Re: **Bradley Heights PUD Development Plan- Filing 1 & 2 – File # AR PUD 21-00206 – Responses to 1st Round Comments**

We are in receipt of your review letter dated May 13, 2021. Below is a point by point response to these comments prepared in coordination with the Developer (Challenger Homes) and the Design Team.

SHEET
SP

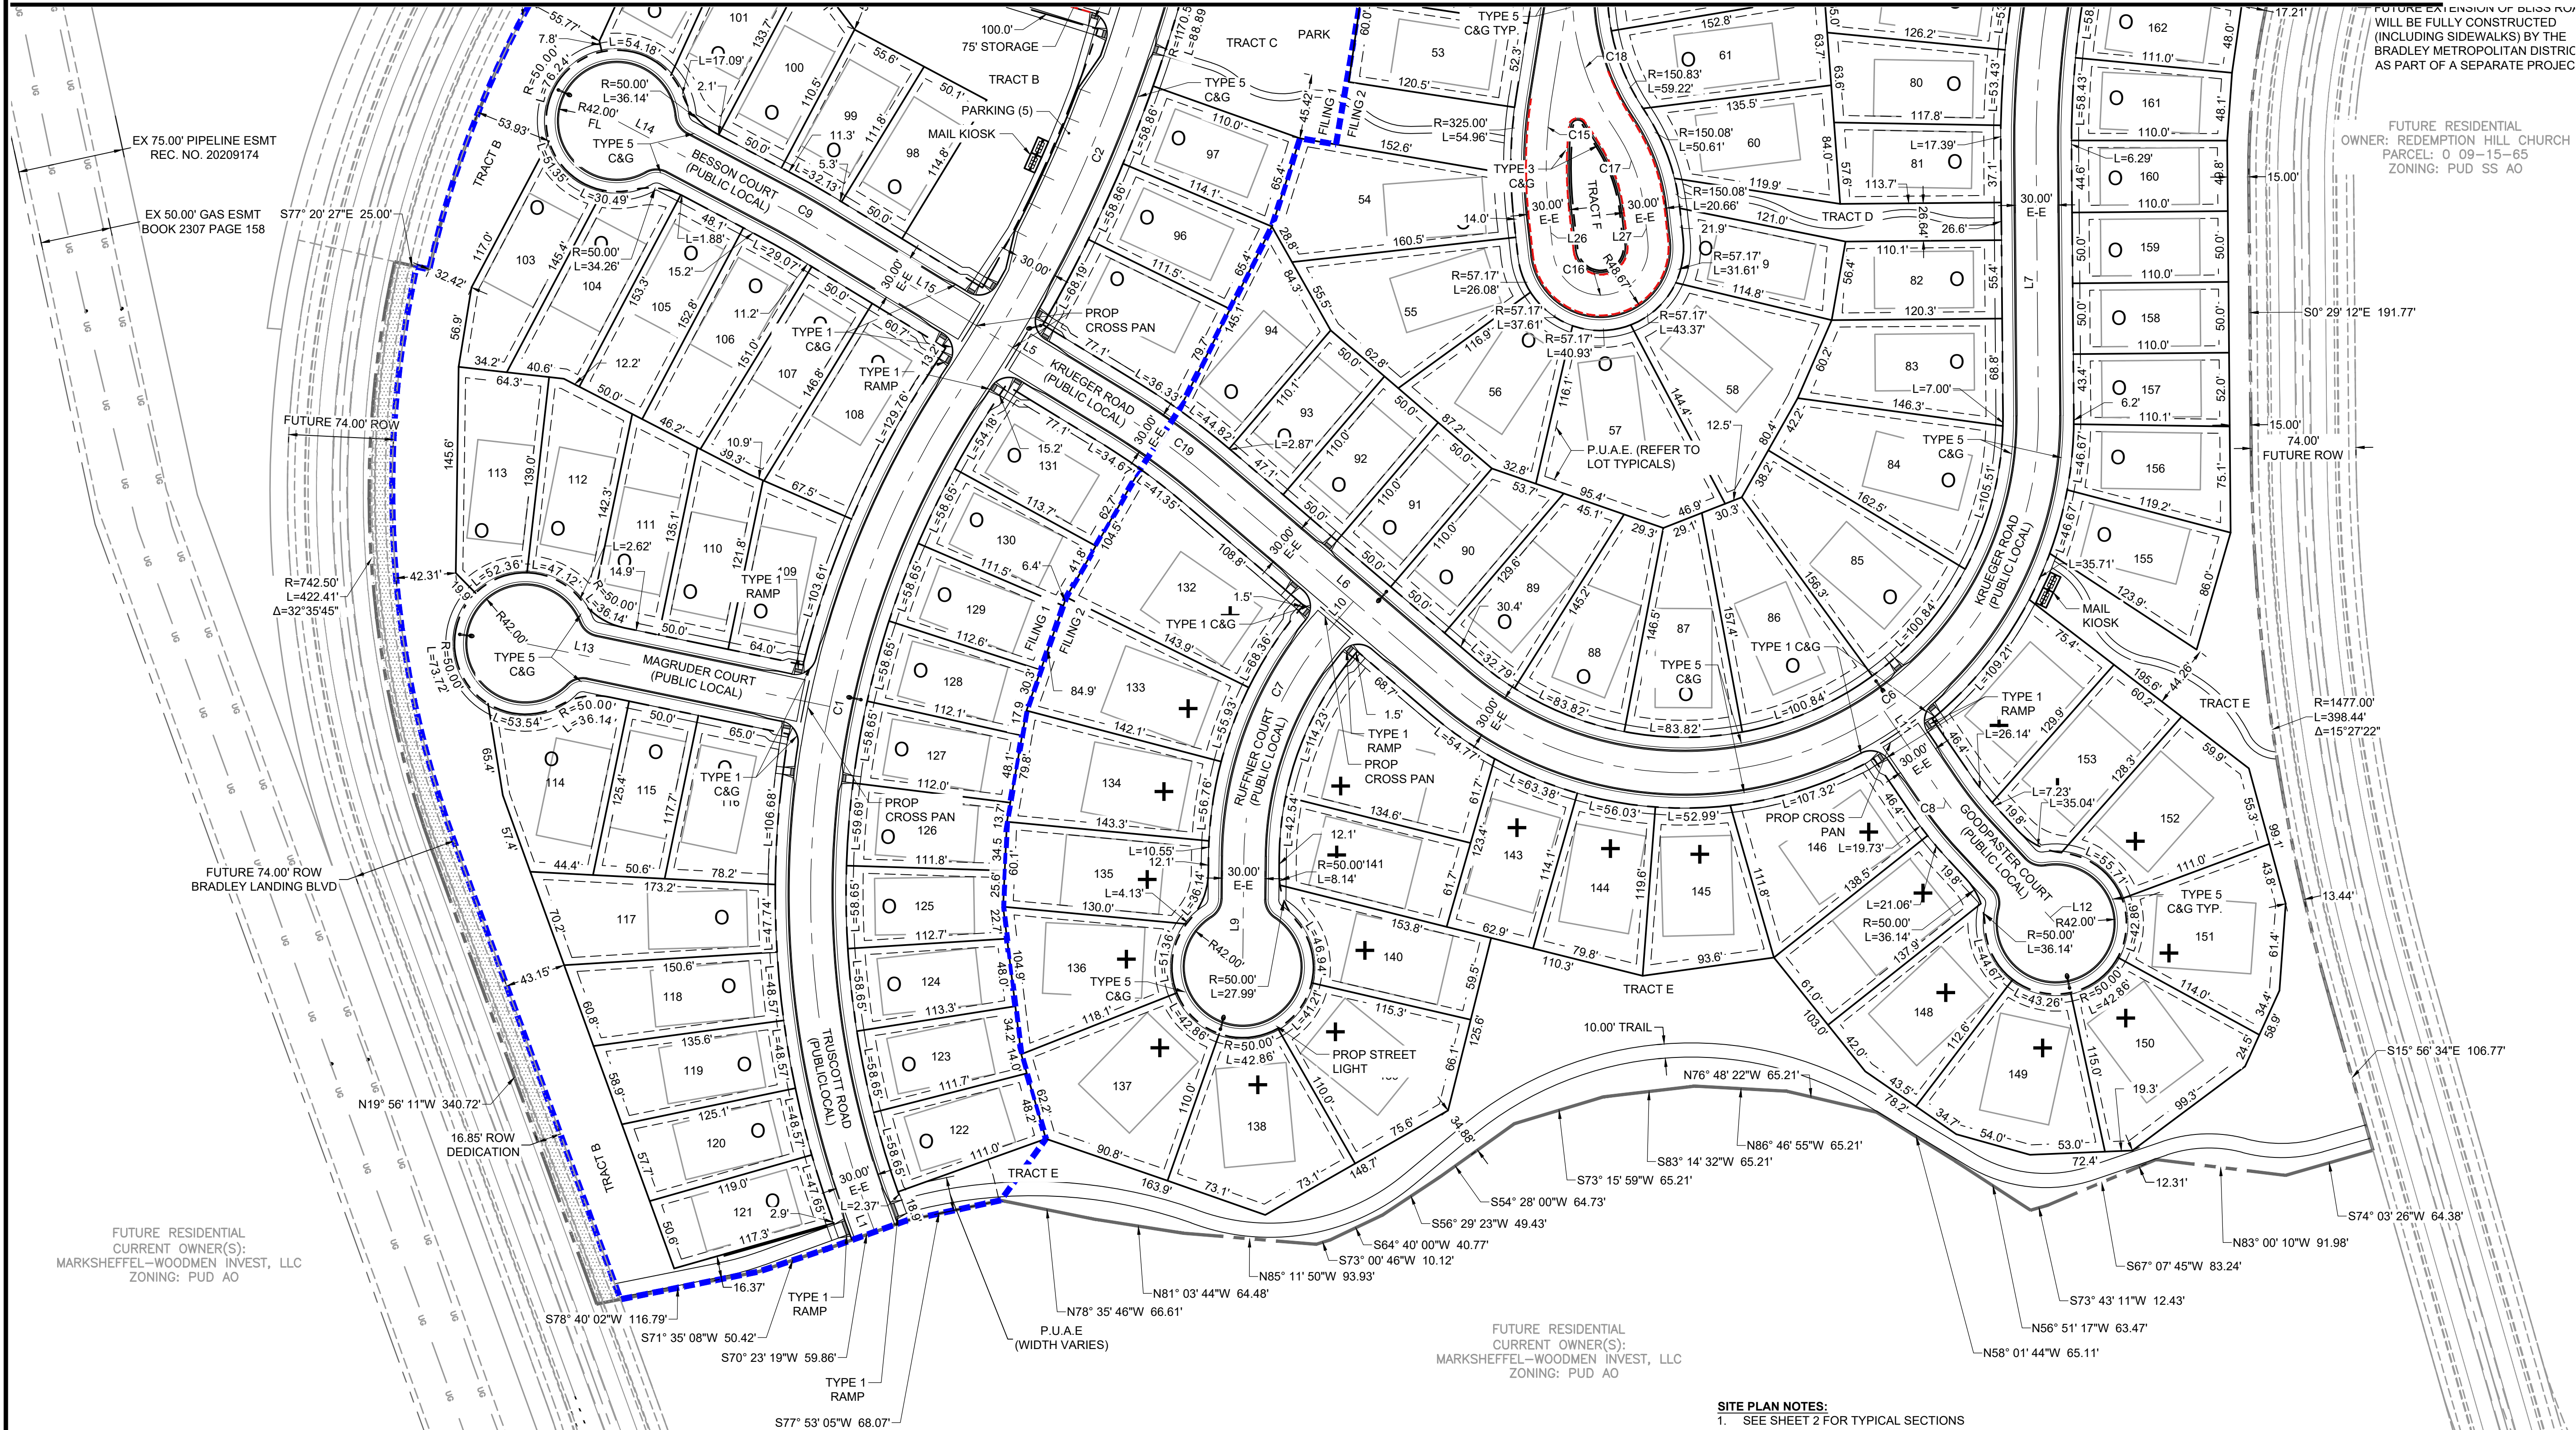
2. Please ensure there are no lot areas within the 50-foot wide open space tract along Bradley (see Sheet 3).

4. Address how and when the trail along Bradley will be constructed and by whom.

7. Show proposed location of street lights on site plan.

HR Green Response: Confirmed. The south edge of the tract is the north property lines for the lots abutting the tract.

HR Green Response: Note 3 added to the sheet 3: THE PROPOSED 10' TRAIL ALONG BRADLEY ROAD WILL BE CONSTRUCTED BY THE DEVELOPER WITH THE CONSTRUCTION OF FILING 1.

HR Green Response: Locations already in plan, labels added to sheets 3-5 for clarification.

SMALL LOT PUD DEVELOPMENT PLAN
PRELIMINARY GRADING PLAN - SOUTH

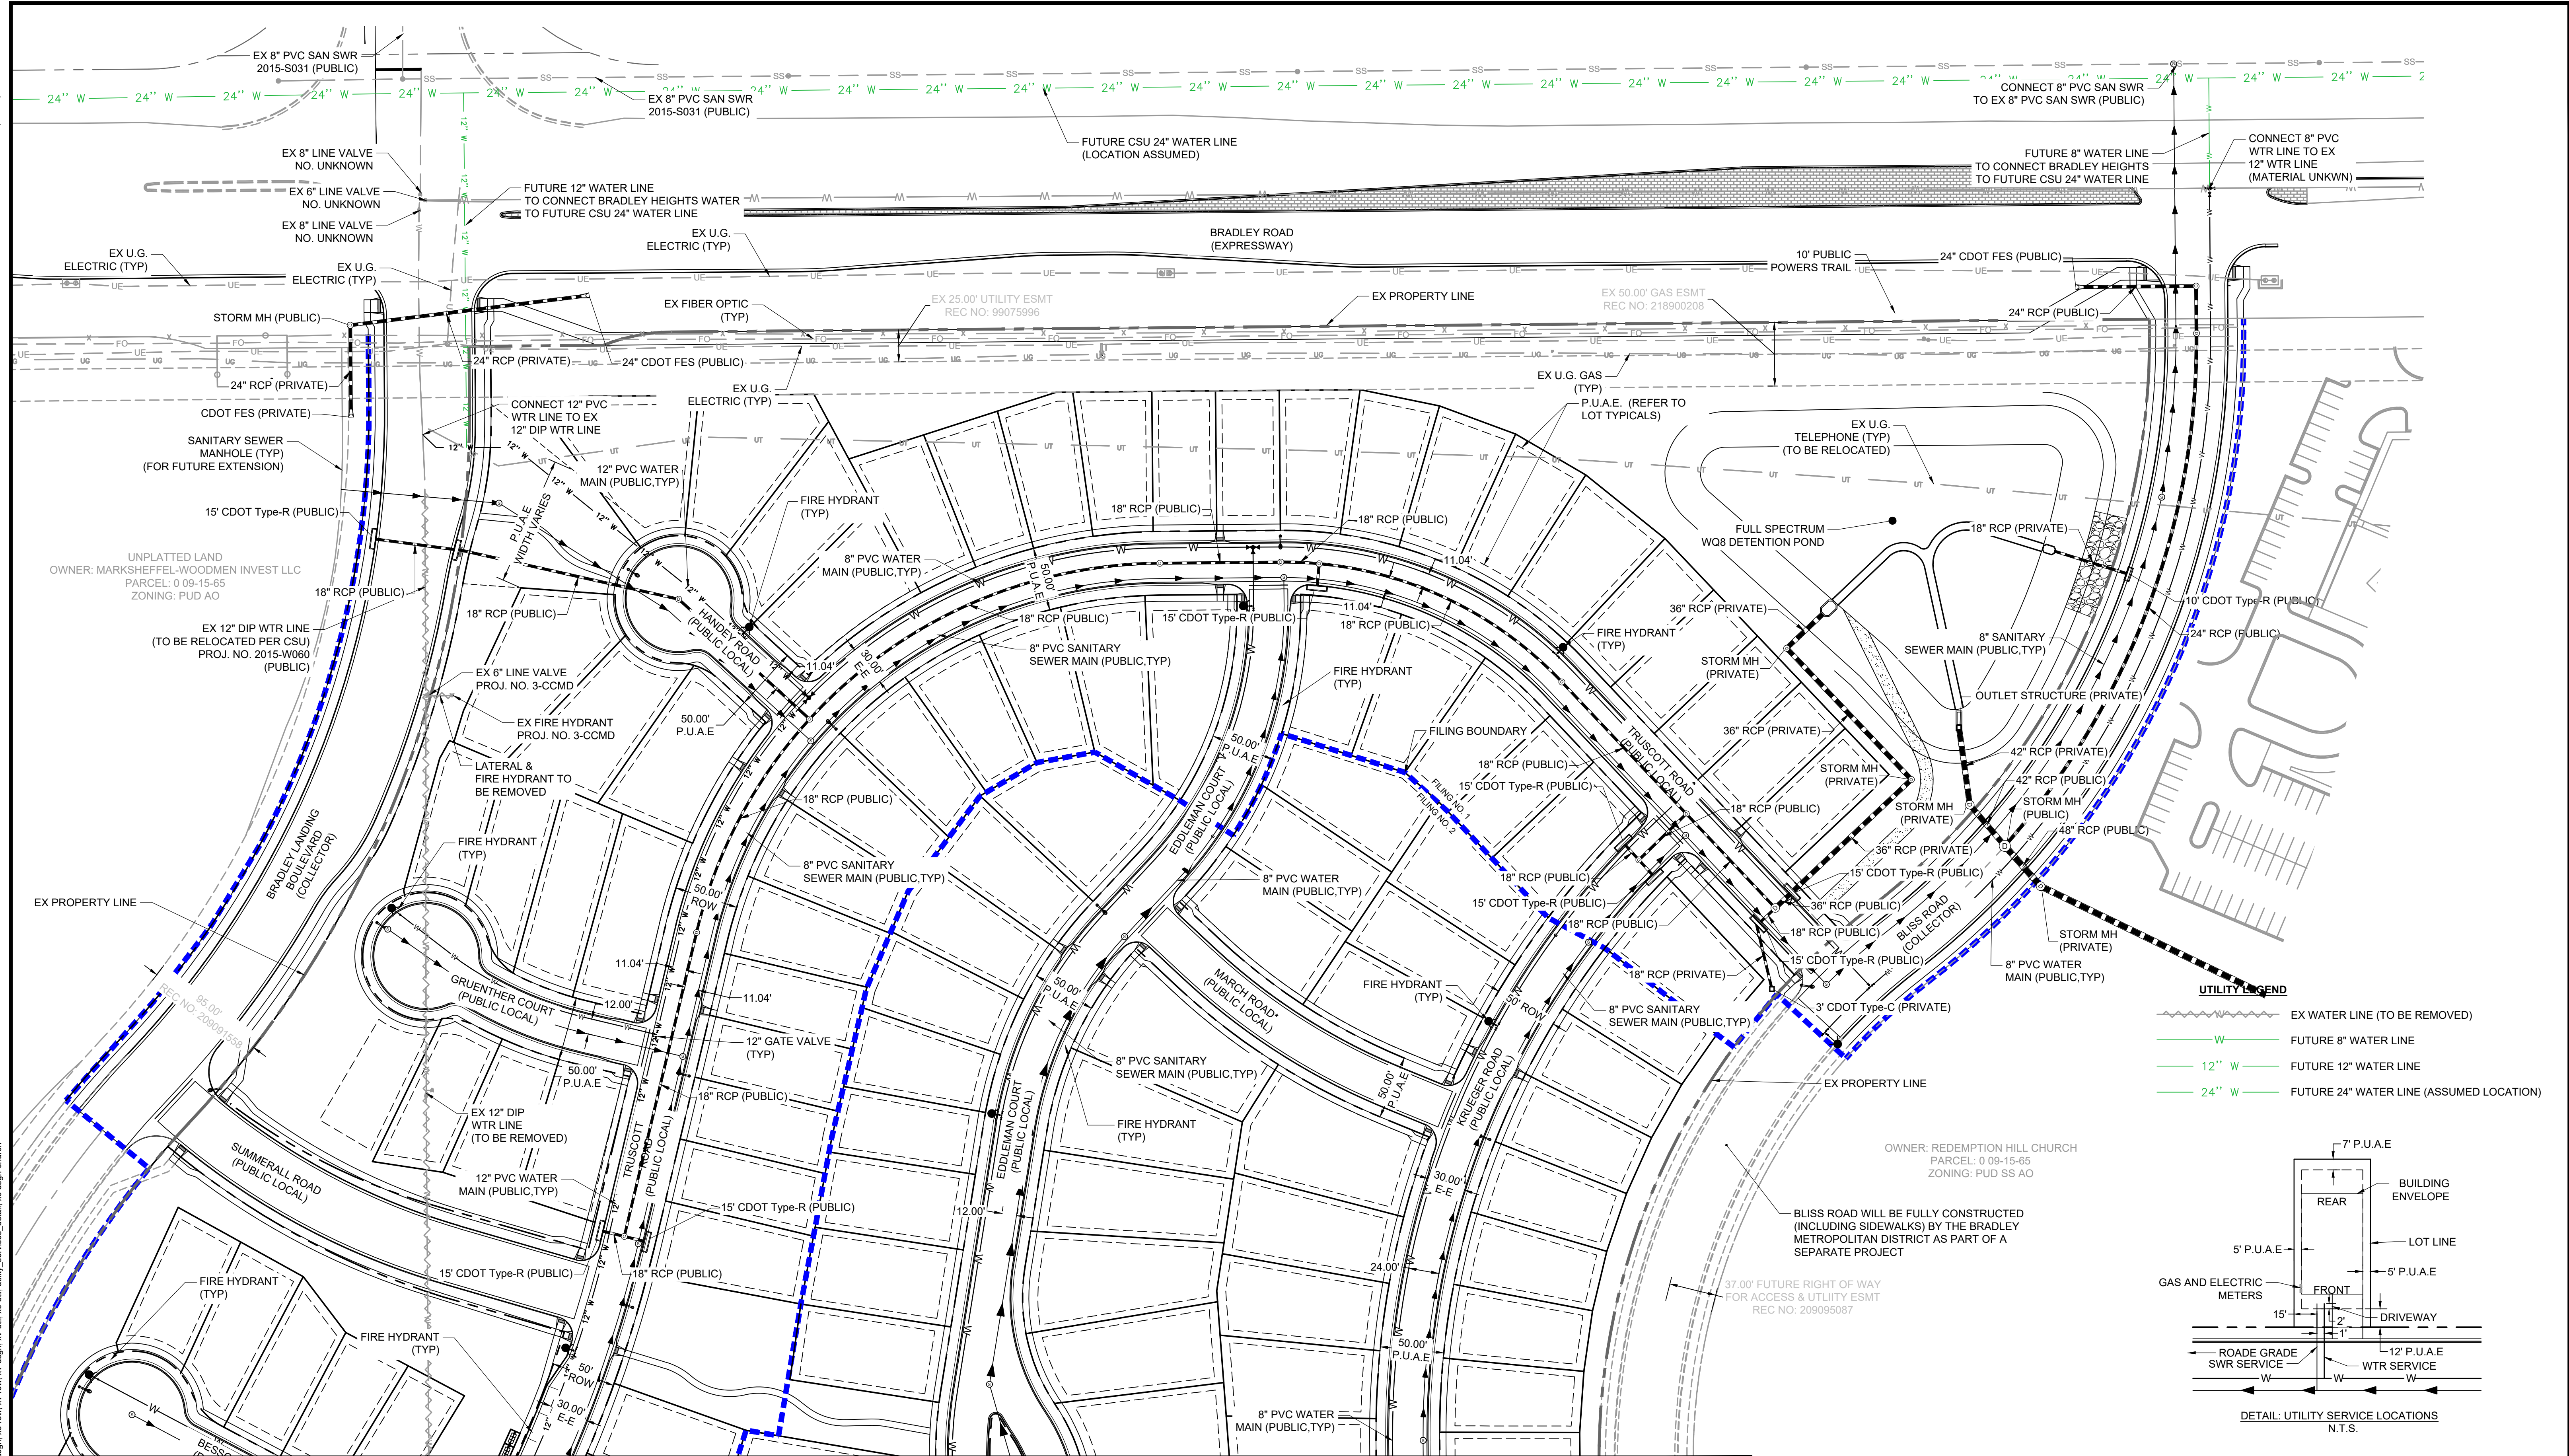
6. Confirm whether any retaining walls are to be utilized? If so, show on grading plan and denote T.O.W. and B.O.W.

HR Green Response: One wall has been added to the Plan (see lot 21) grades have been added accordingly.

PUD DEVELOPMENT PLAN
PUBLIC UTILITY & FACILITY PLAN - NORTH

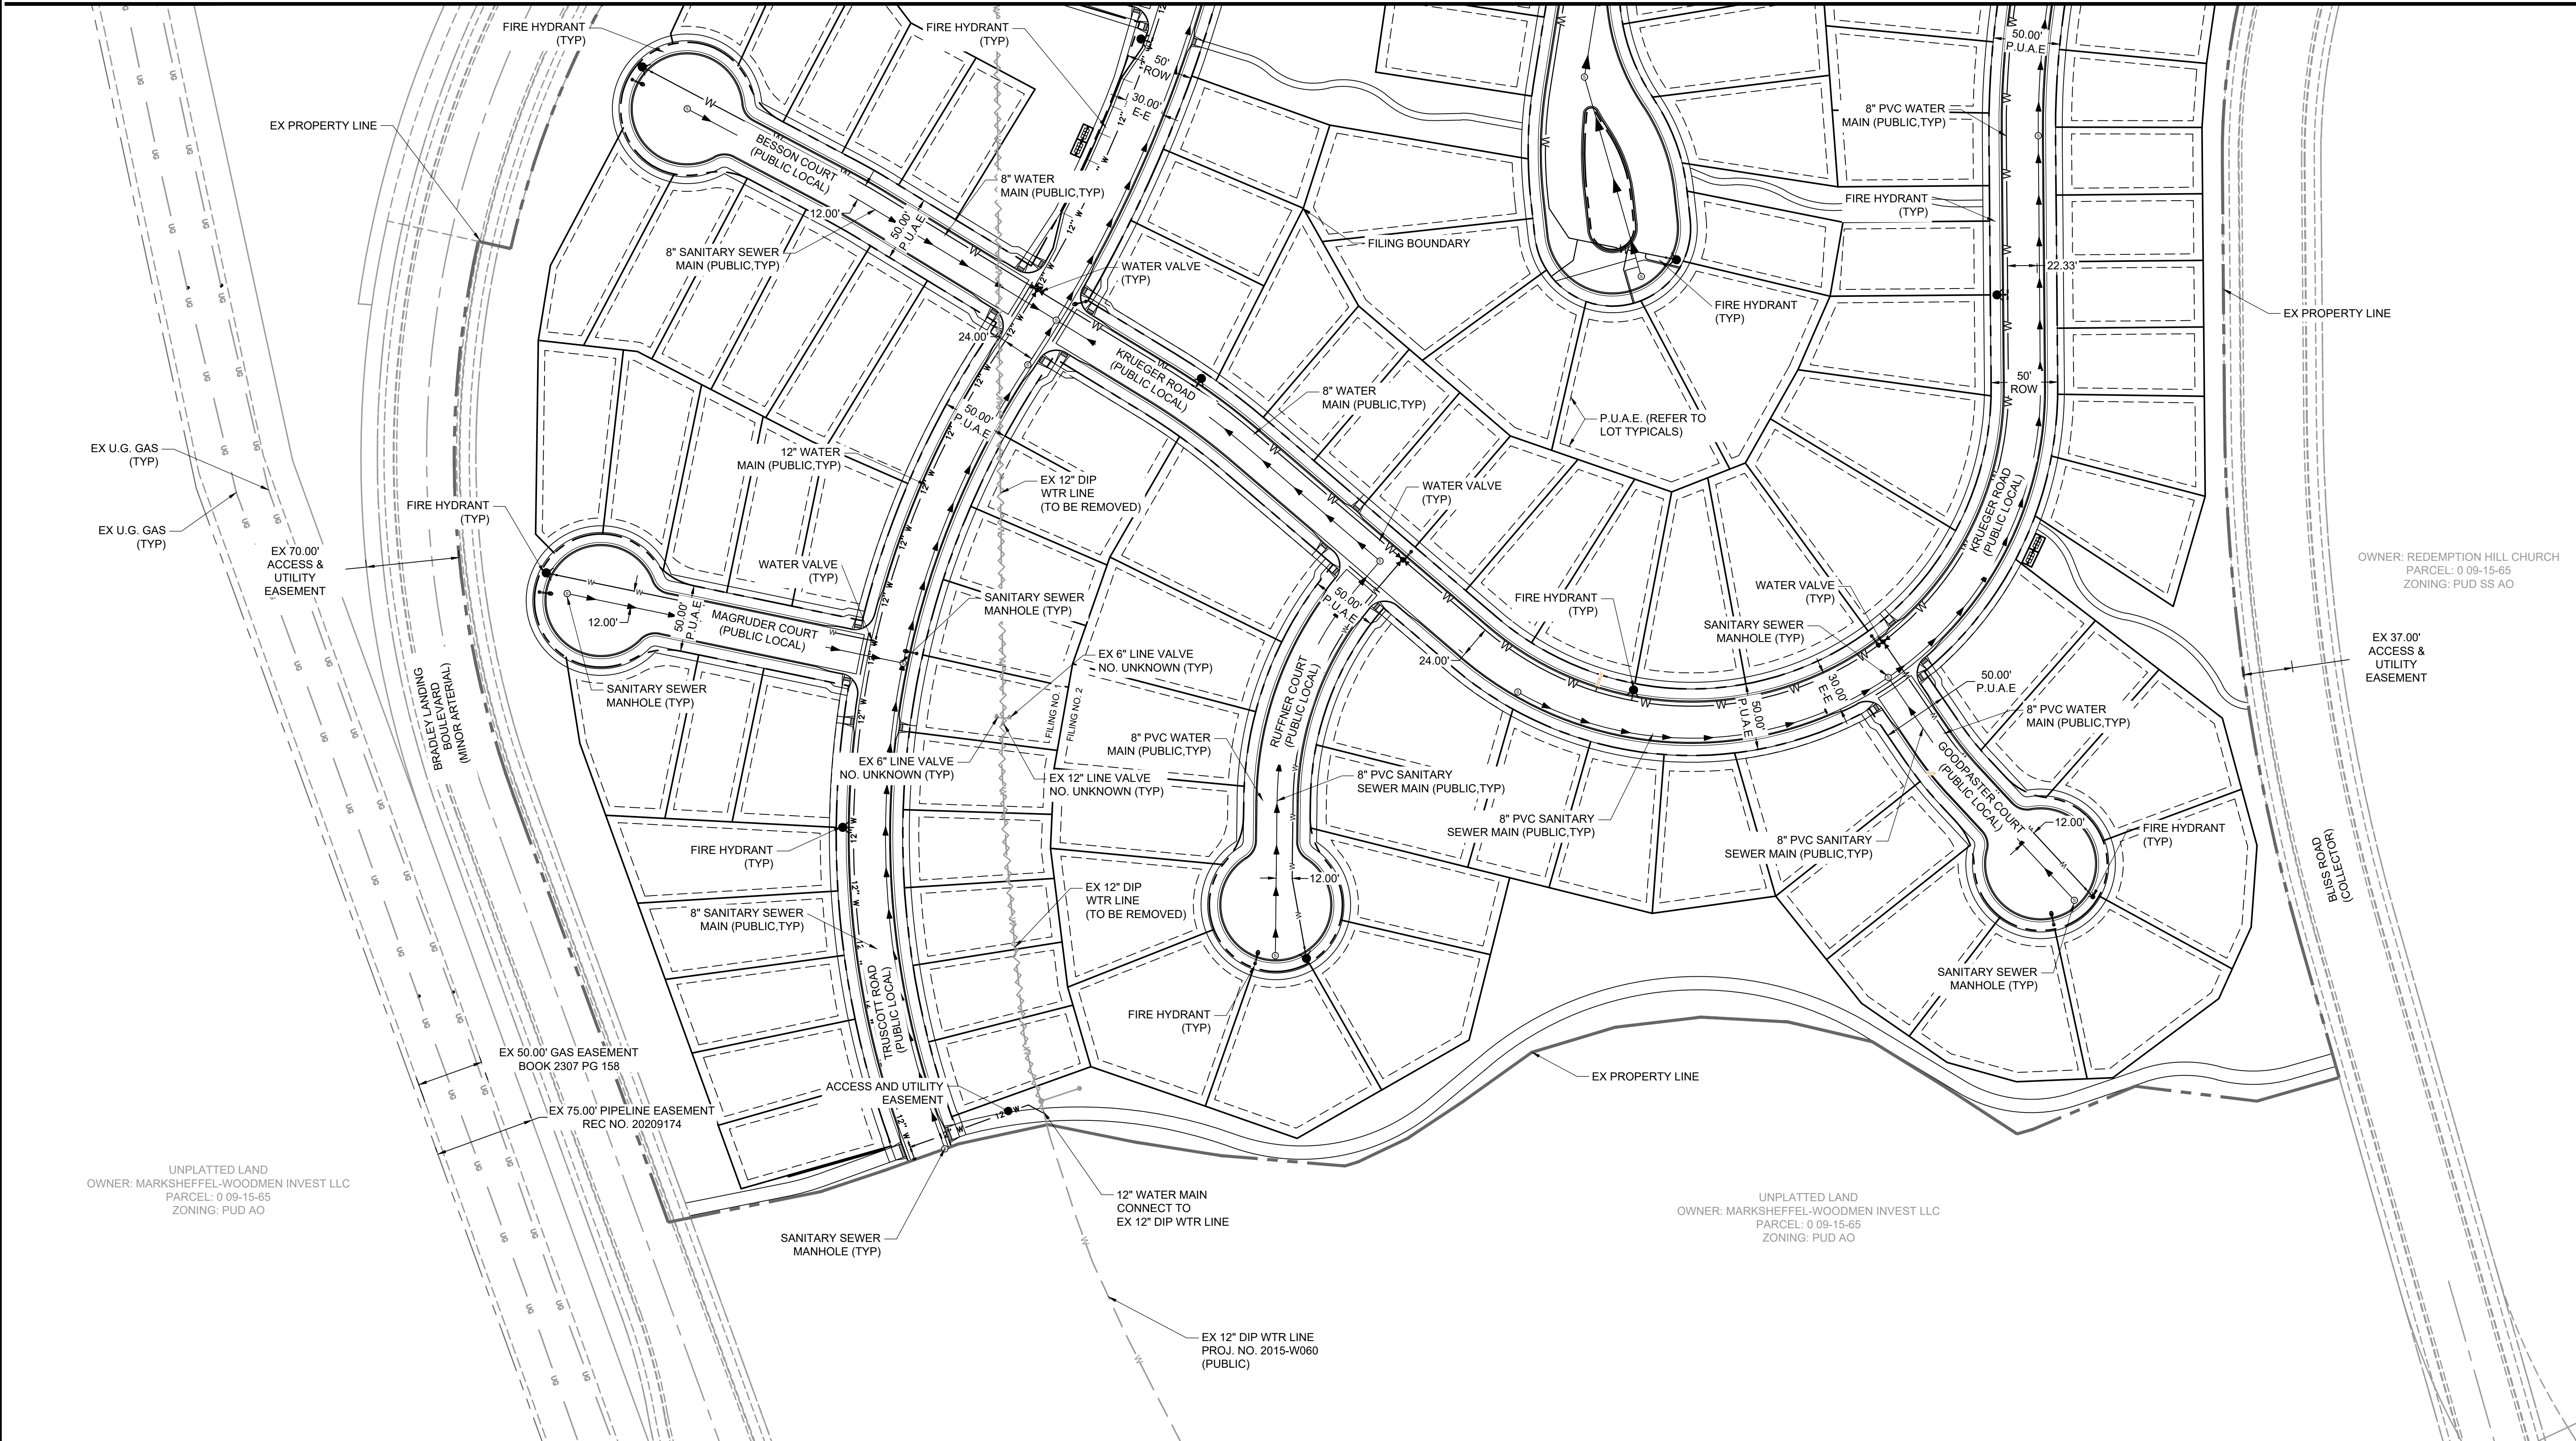
4. Per city code water and wastewater mains must be extended to furthest extent of property. Please revise appropriately for Filing No 2 down Bliss Dr.
HR Green Response: We are continuing to coordinate with the Bradley Heights Metropolitan District to address this item. They are working on an overall water and wastewater Master Utility Plan that will address the needs for the overall development. Based on our initial review of the existing topography an extension of the sanitary sewer along Bliss Road to the southern limits of this project would not provide usable sewer service to the south. Water lines will be extended along this road as part of the District improvements.
